**Location:** Honfleur 3 Grindleton View Chatburn BB7 4BE  
**Proposal:** Proposed new dwelling and creation of new access on land to the side of 3 Grindleton View.  
**Grid Ref:** 377062 444303

The Local Highway Authority (LHA) are in receipt of an application for the proposed new dwelling and creation of new access on land to the side of 3 Grindleton View, Chatburn.

Proposed Site Plan
Scale (1:500)

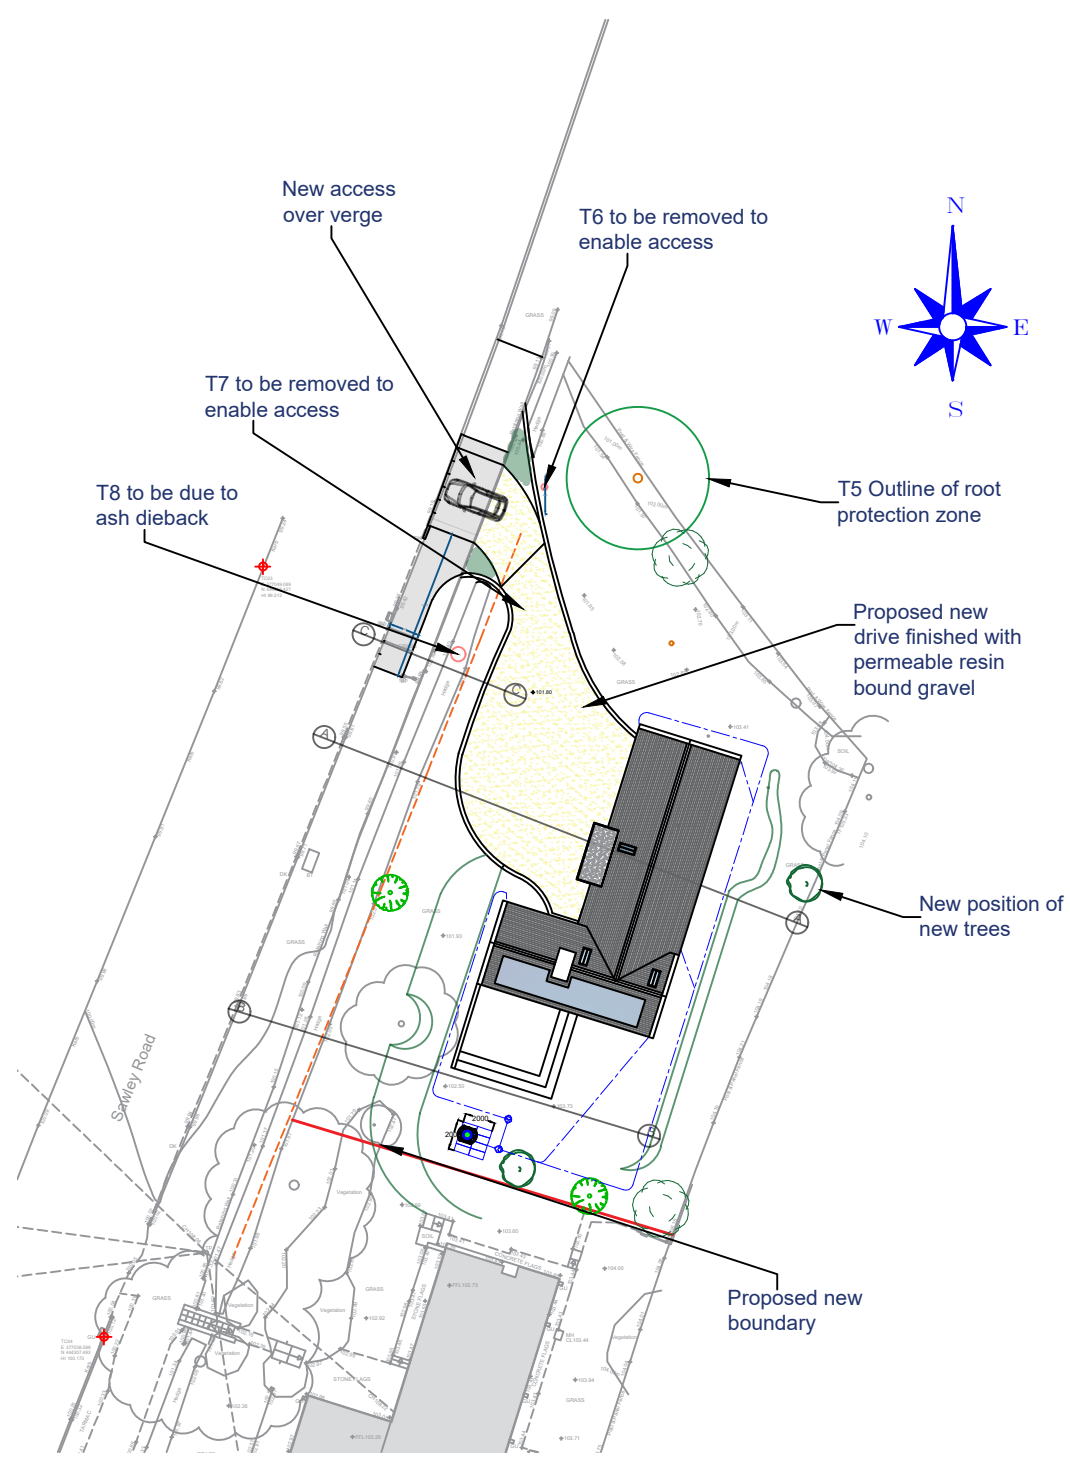
The LHA has reviewed the proposed site plan, drawing 010, and drawing 04 Rev. C titled Proposed Visibility Splay Plan and are aware that the proposed 5.5m access can provide visibility splays of 2m x 102m in both directions. The LHA are satisfied with the provided visibility splays due to the findings of the traffic survey, which found that the 85th percentile speeds along Sawley Road were 40.7mph northeast bound and 38.3mph southwest bound. The access shall be hard paved for at least the first 5m into the site and drainage shall be provided at the access to prevent surface water from discharging onto the highway.

The LHA has reviewed the proposed site plan, drawing 010 and are aware that the parking arrangements comply with the LHAs parking guidance as defined within the Joint Lancashire Structure Plan.

The recommended minimum internal dimensions for a double garage size is 6m in length and 6m wide. The recommended distance of 6m is based on the length of a large family car (Ford Mondeo Estate 4.58m long), clearance at the rear of the car (200mm), overhang of the garage door (600mm) and room to stand in front of the car and open/close the garage door (600mm). As the proposed garage meets the recommended minimum internal dimension, it can be counted as a parking space.
